WEST SUSSEX COUNTY COUNCIL CONSULTATION

TO:	<u>Arun</u> District Council <u>FAO:</u> Raymond Cole
FROM:	<u>Stephen Gee</u> <u>WSCC</u> - Highways Authority
DATE:	6 August 2020
LOCATION:	Land East of <u>Fontwell</u> Avenue <u>Fontwell</u> <u>BN18 0SB</u>
SUBJECT:	<u>BN/57/19/RES</u> Approval of reserved matters following the grant of WA/22/15/OUT for a 2 No. non-residential buildings. An amendment received.
DATE OF SITE VISIT:	<u>n/a</u>
RECOMMENDATION:	No Objection
S106 CONTRIBUTION TOTAL:	n/a

DRAWING
Proposed Industrial Unit
Arundel Road, Fontwell
Block Plan

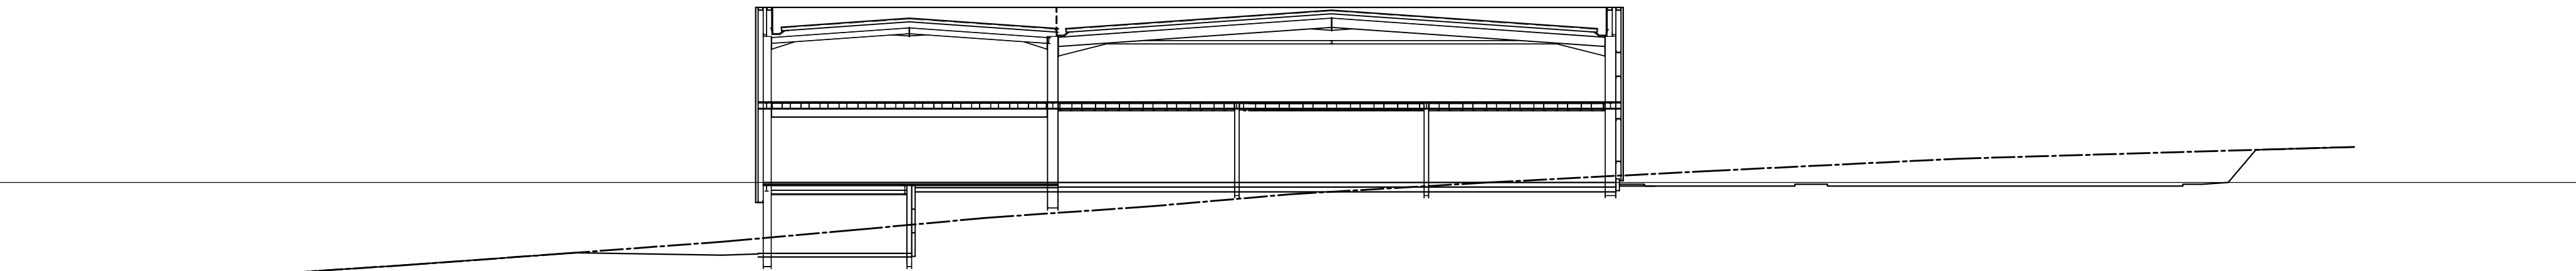
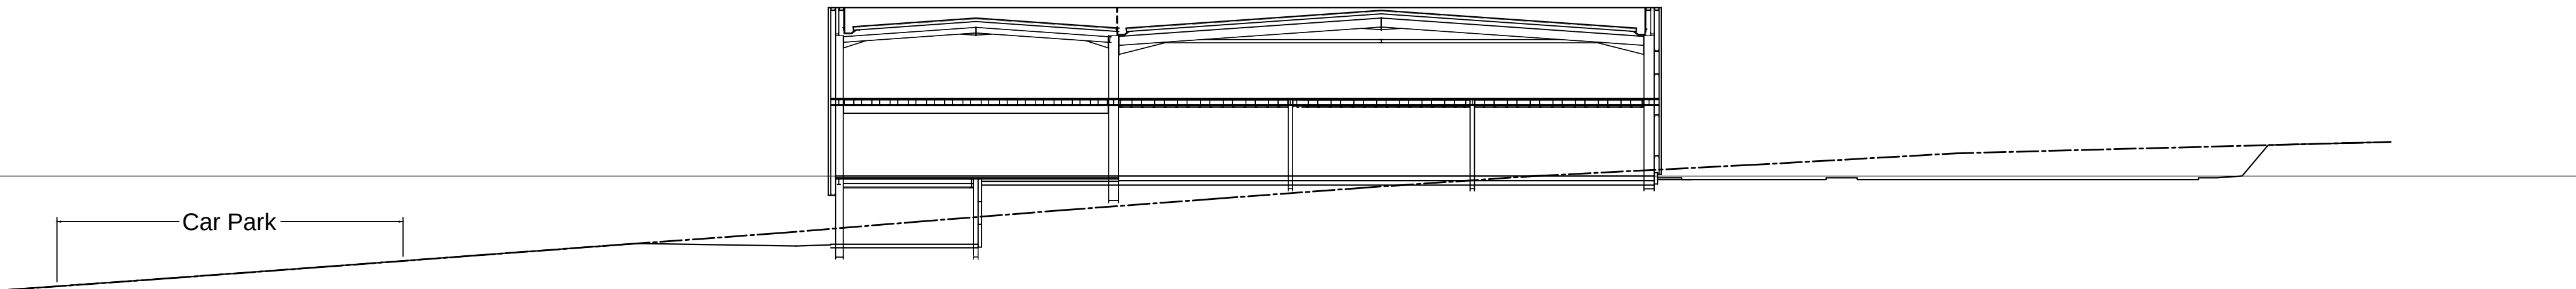
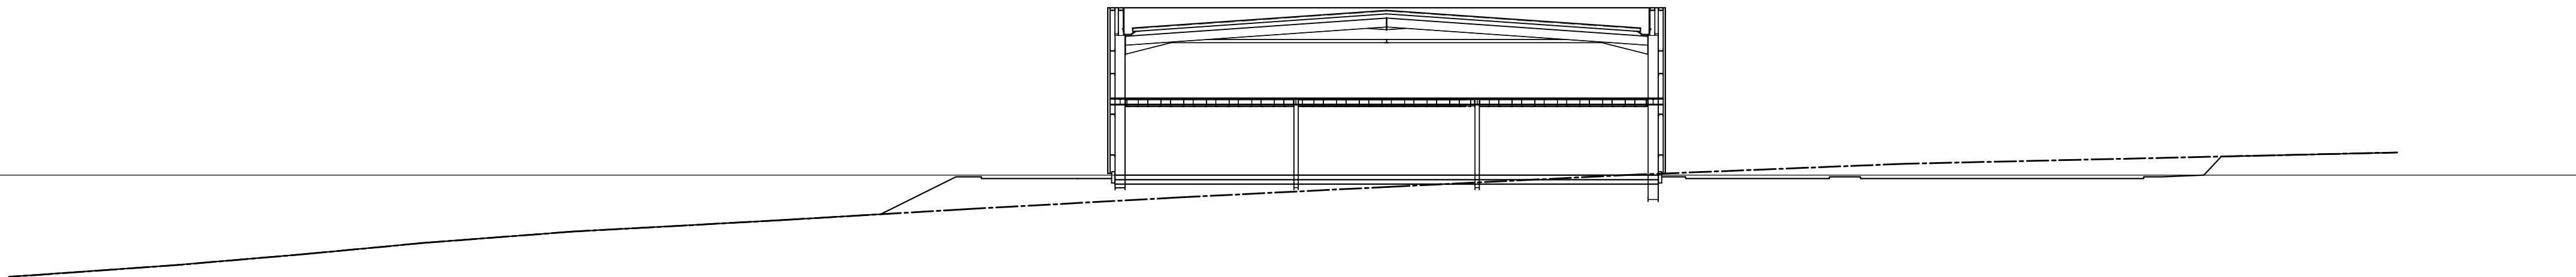
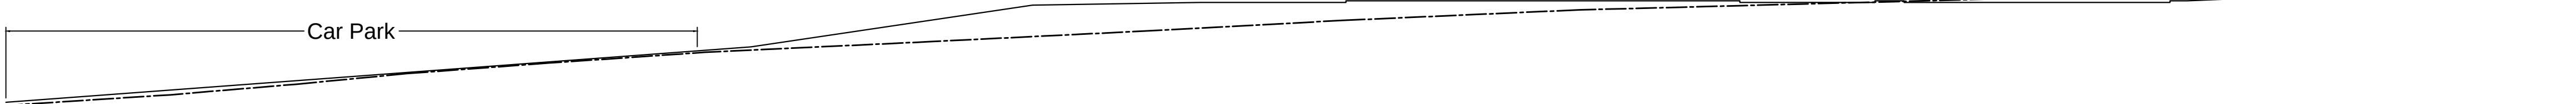
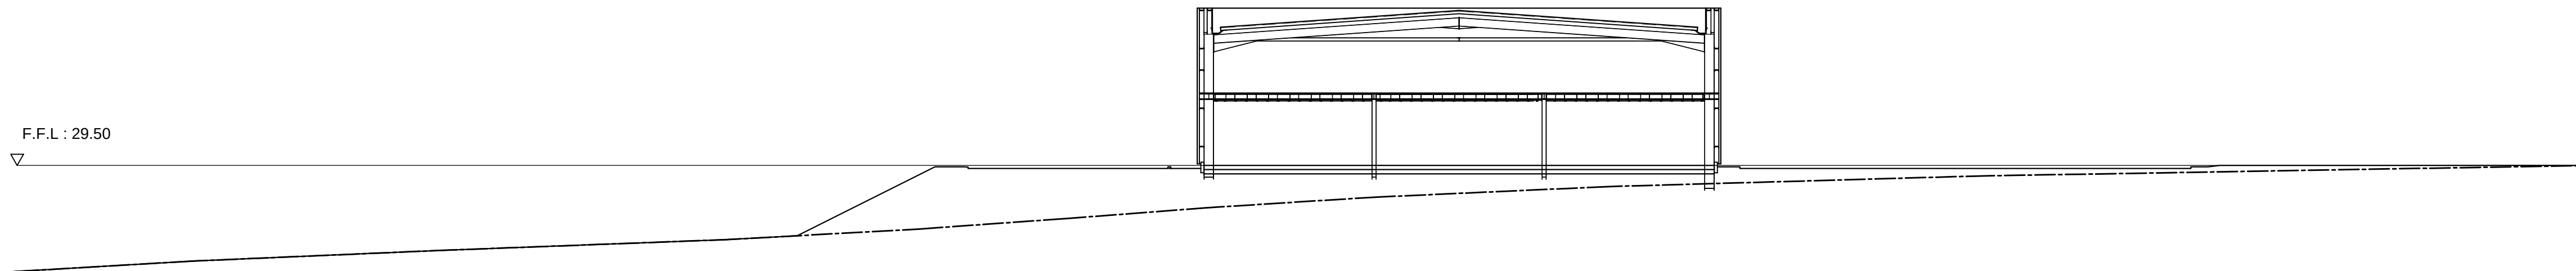
A total of 105 parking spaces are shown on Block Plan 500 (of which 25 provide electric vehicle charging) and 6 motorbike parking spaces. It is noted the applicant has not provided a justification for the level of car parking however the over provision over ADC standards would reduce the potential for parking outside of the site, whilst no objection is raised to the level of parking the level could reduce the impact of any travel plan measures to be developed (secured in condition of APP/C3810/V/16/3143095).

34 cycle parking spaces are shown on Block Plan 500

Tracking has been provided for a refuse vehicle and fire tender and is acceptable.
